**WELWYN HATFIELD BOROUGH COUNCIL
EXECUTIVE DIRECTOR - PLANNING, PUBLIC PROTECTION AND GOVERNANCE**

DELEGATED APPLICATION

Application No: 6/2017/1375/HOUSE
Location: 20 Kingswell Ride Cuffley Potters Bar EN6 4LH
Proposal: Erection of a single storey rear extension, raised patio area and associated steps
Officer: Mrs K Charles

Recommendation: Granted

PROPOSED SIDE ELEVATION

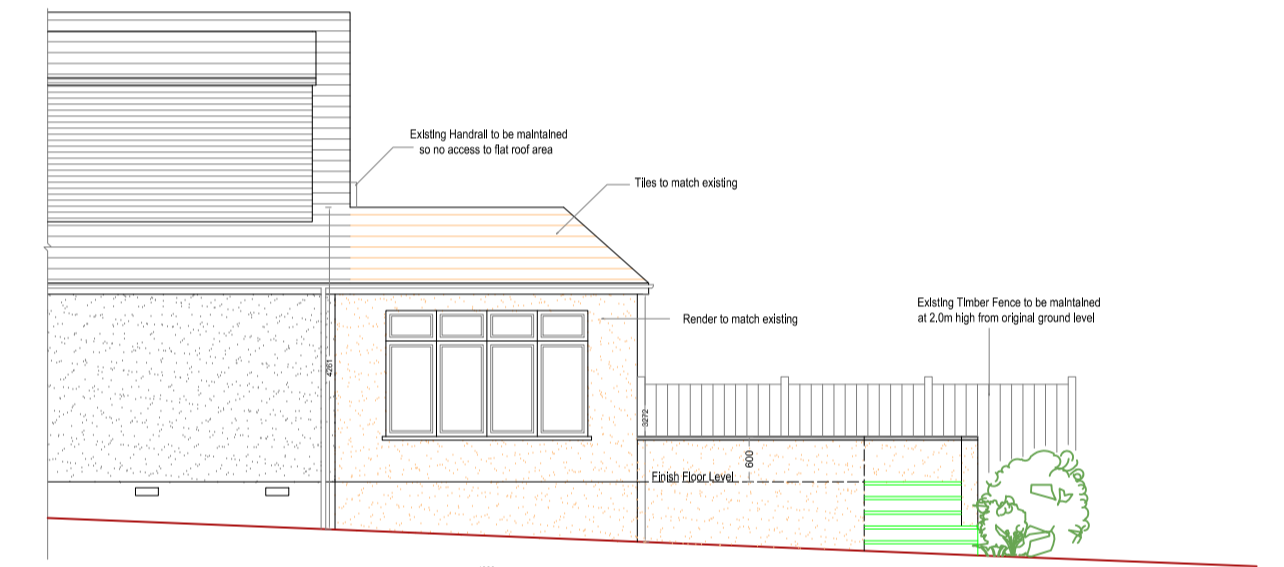
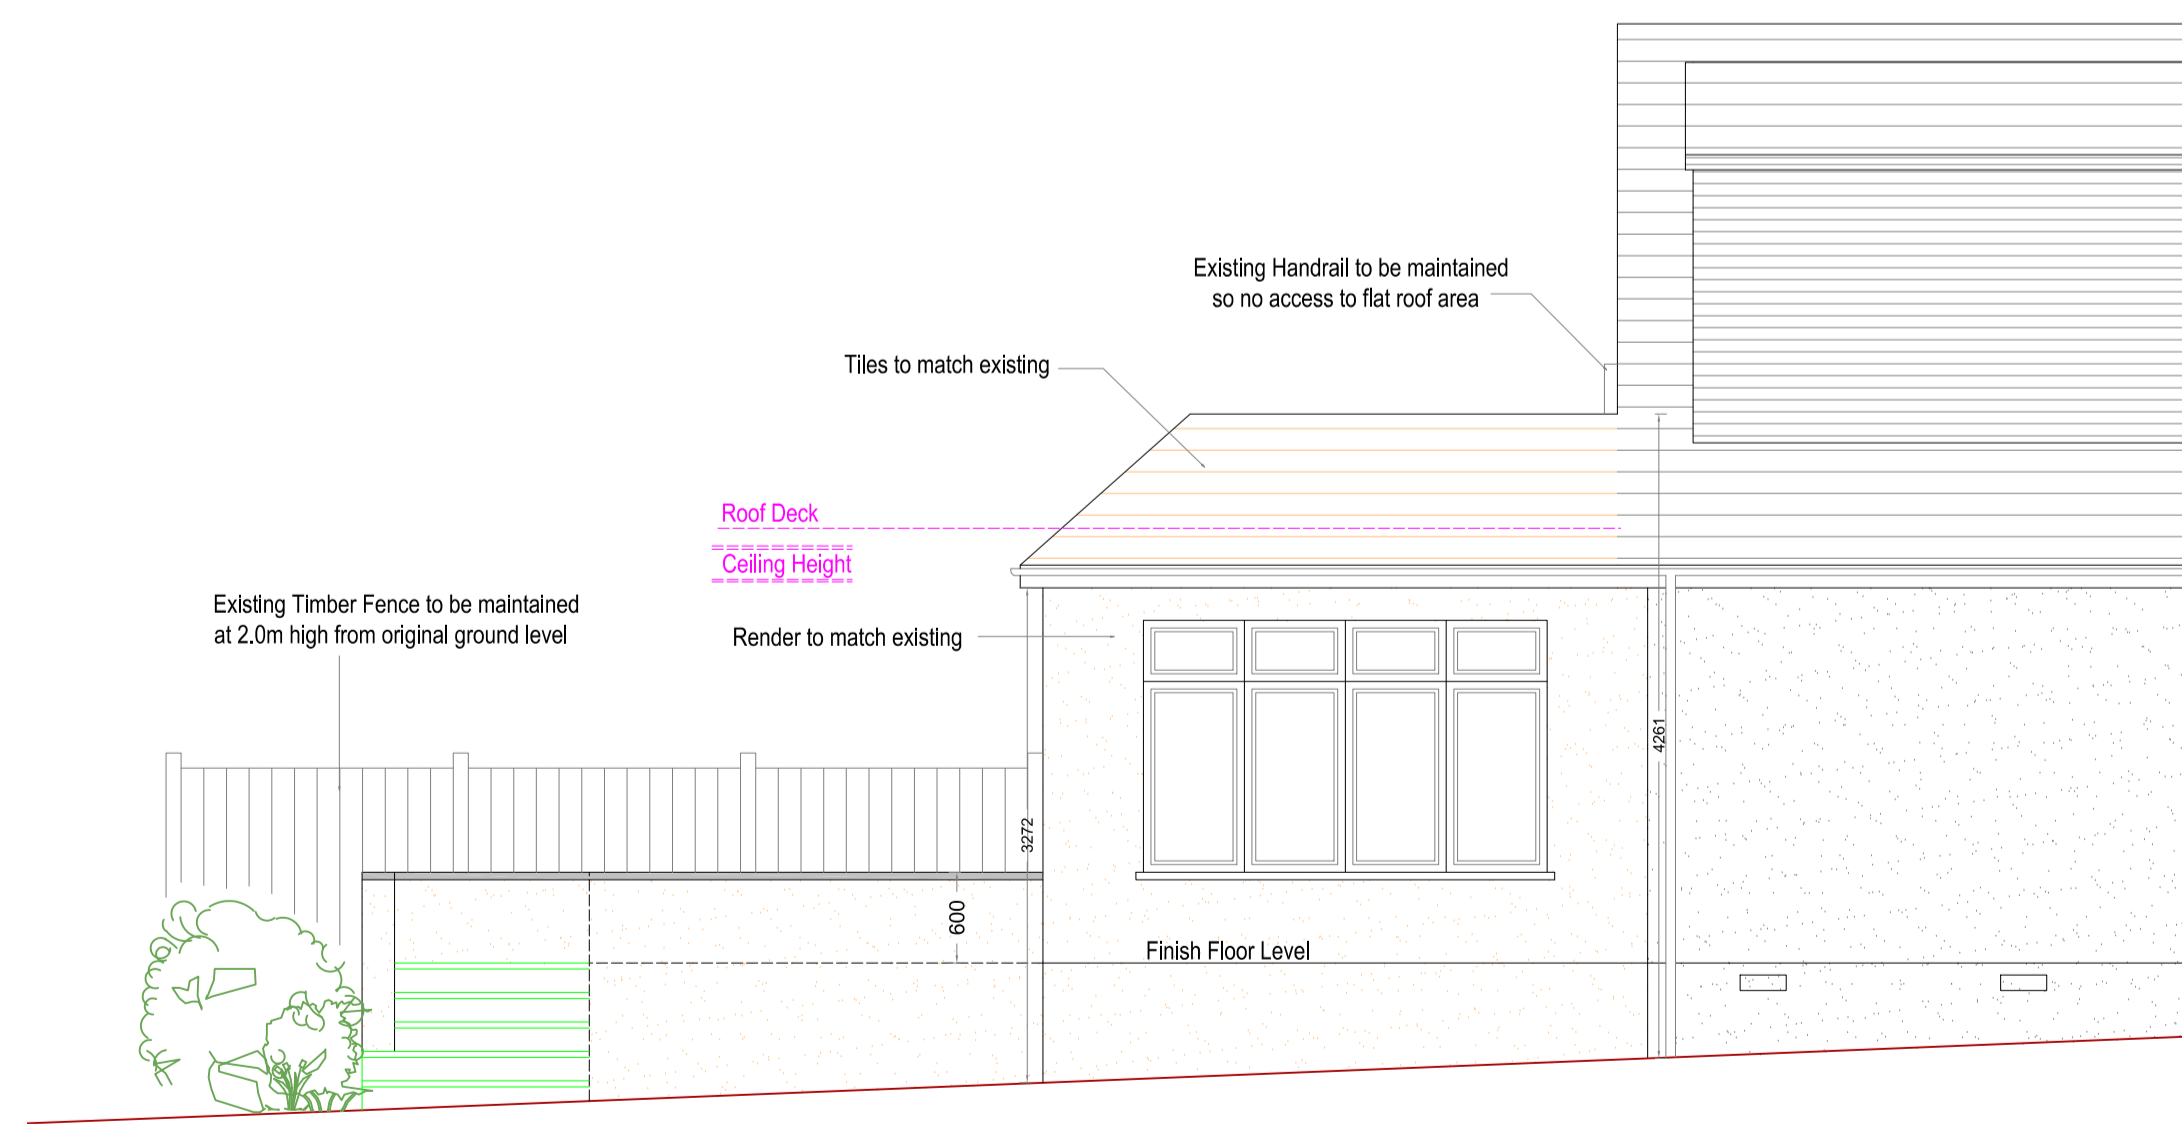
The proposal shows both a raised patio and windows to the flank elevations. Communication has taken place with the applicant who is agreeable to a condition requiring obscured glazing being attached. Although the land slopes downwards quite significantly from front to rear, it is not considered that the raised patio, due to existing boundary treatment would cause a significant amount of overlooking of the adjoining properties that would warrant a refusal.

2. The side windows of the proposed building shall be glazed with obscured glass and shall be fixed so as to be incapable of being opened below a height of 1.8 metres above floor level, and shall be retained in that form thereafter.
